To Whom It May Concern

11/14/2024

Summary:

Homeowner: Koami Akligo
Address: 135 Van Winkle St Lillington, NC 27546
Permit #: ERES2410-0065
Project ID: 1052346

**DRAWING NUMBER:** PV5

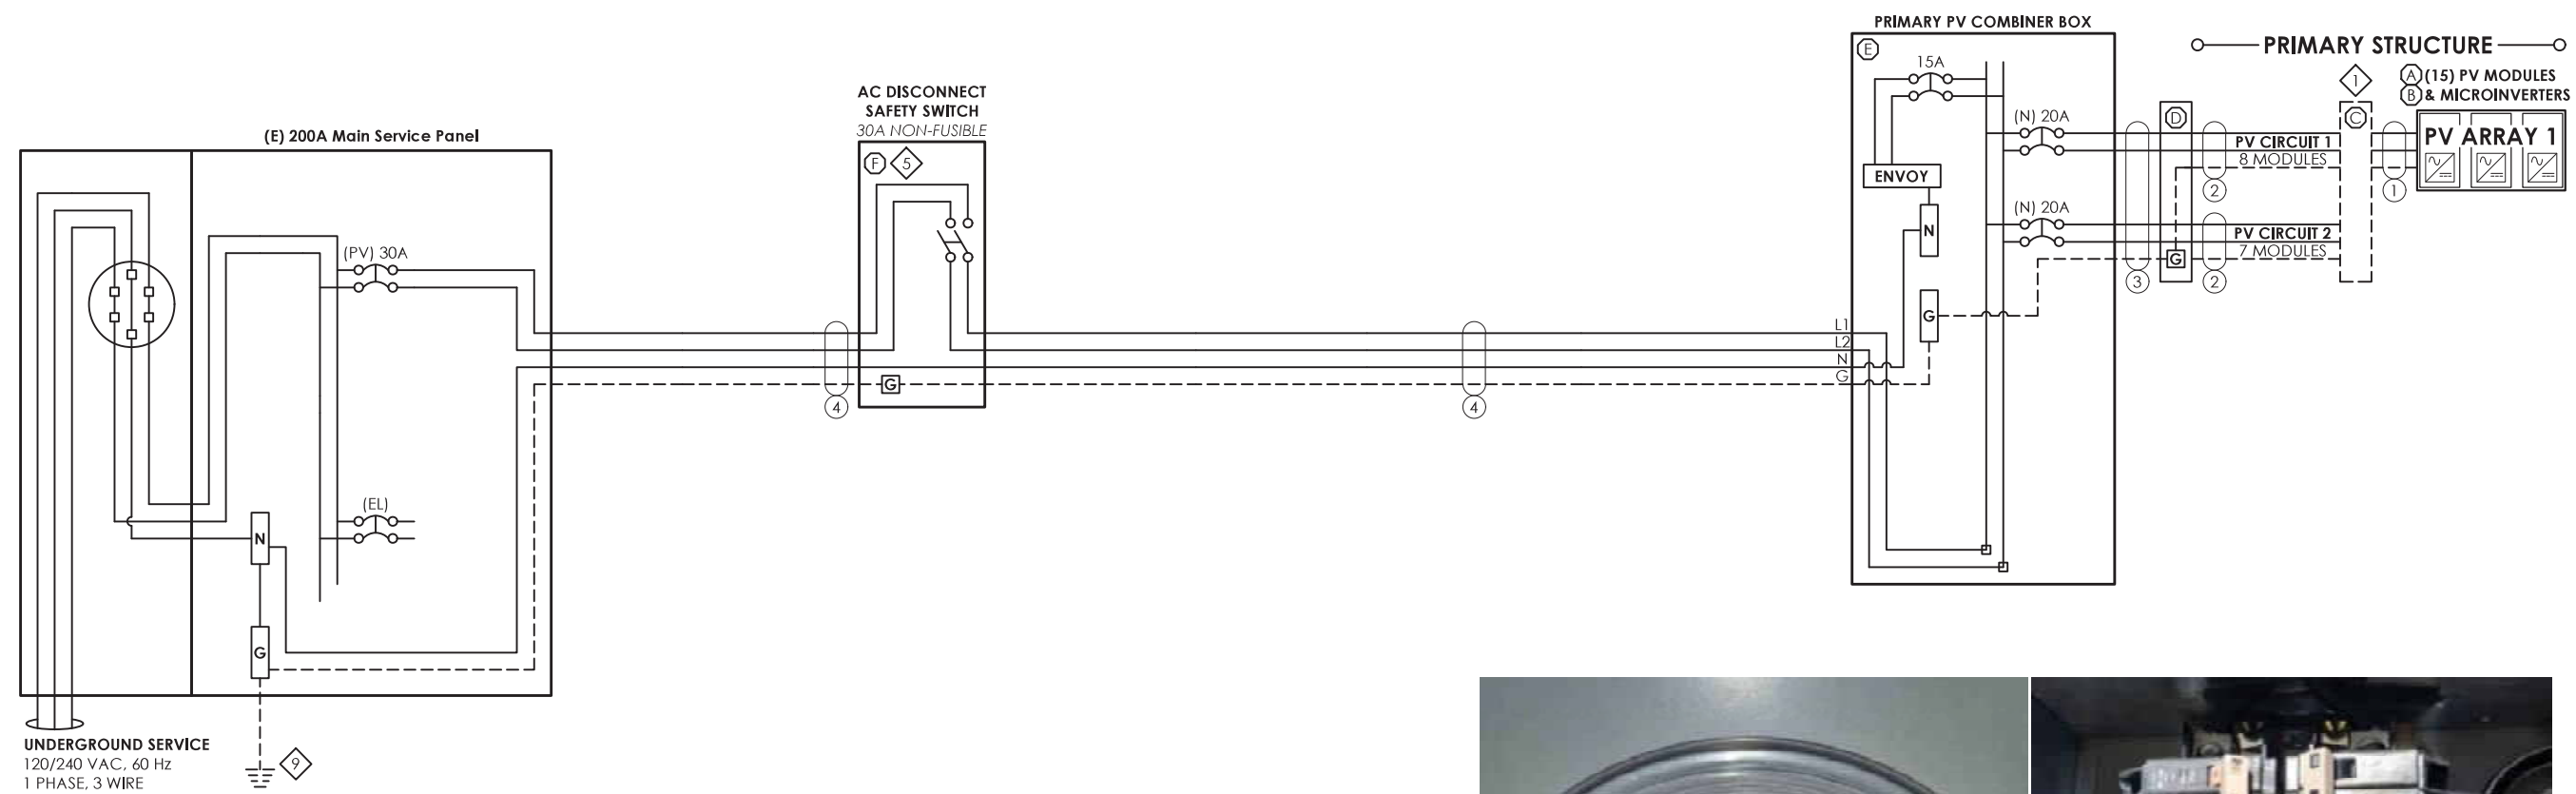
“Dc voltage lines must be ran in conduit romex is not approved.”

Please note that all our conductors in the attic and through our conduit are AC circuit (voltage) conductors. Blue Raven Solar installations virtually always use microinverters installed directly to each solar panel, and as such, the current traveling through our equipment is all AC. Romex should be appropriate for this use.
